Planning Application Ref: AW/214/17/T

Location: 8 Arun Way, Aldwick Estate, Aldwick

Description of works: Various works to trees as listed individually in the application

8 ARUN WAY TREEWORKS

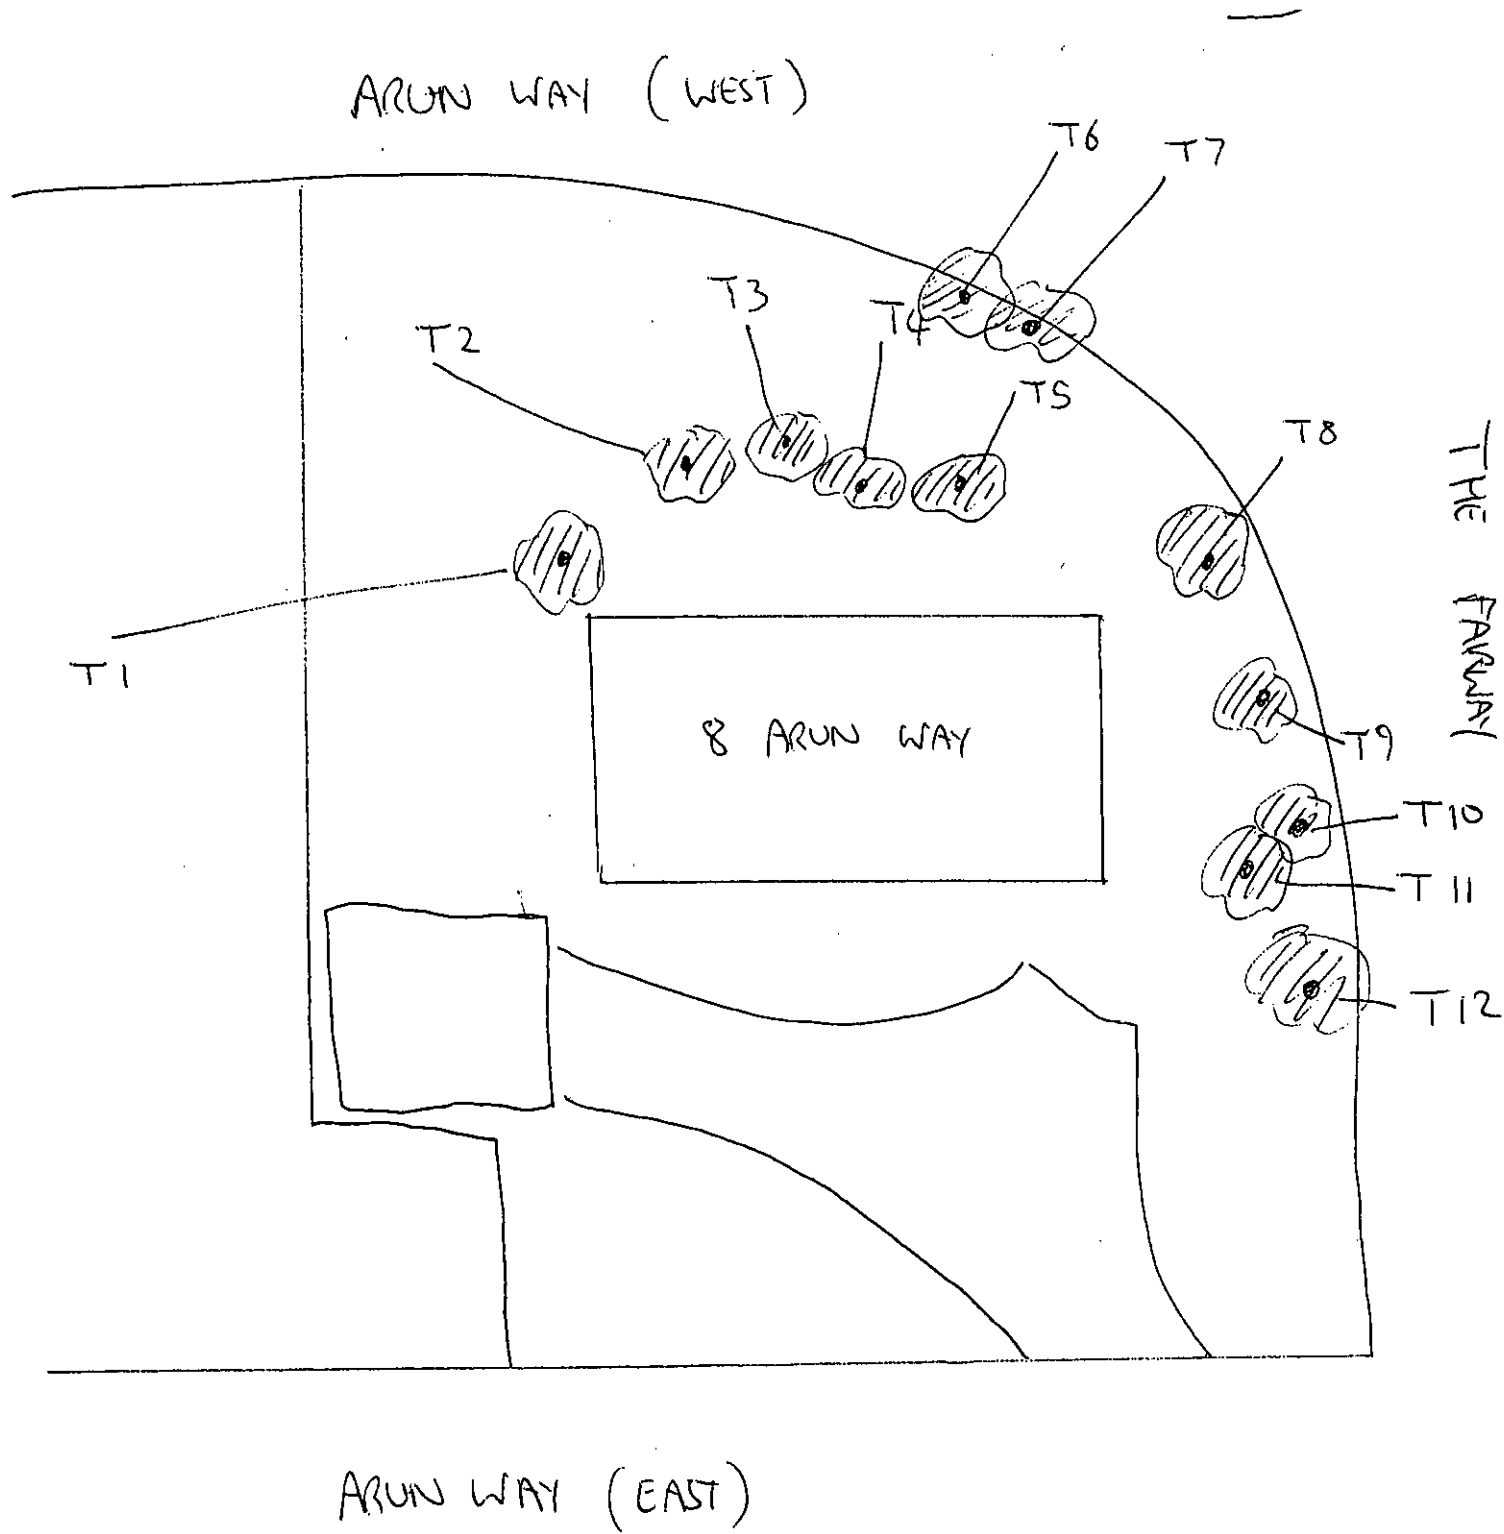
- Having reviewed the works listed for each tree they are all sensible and acceptable amounts of pruning that will ease the overbearing nature that these trees have collectively on this garden.

- I recommend **APPROVAL** for all of the works listed in the application.

- Where whole branches are to be removed and final cuts made close to the trunk or branch union they are to be made as shown in Figure 2 of BS3998:2010
- Where branches are to be shortened back the final cuts are to be made at the correct angle shown in BS3998:2010 and adjacent to a live bud or lateral.
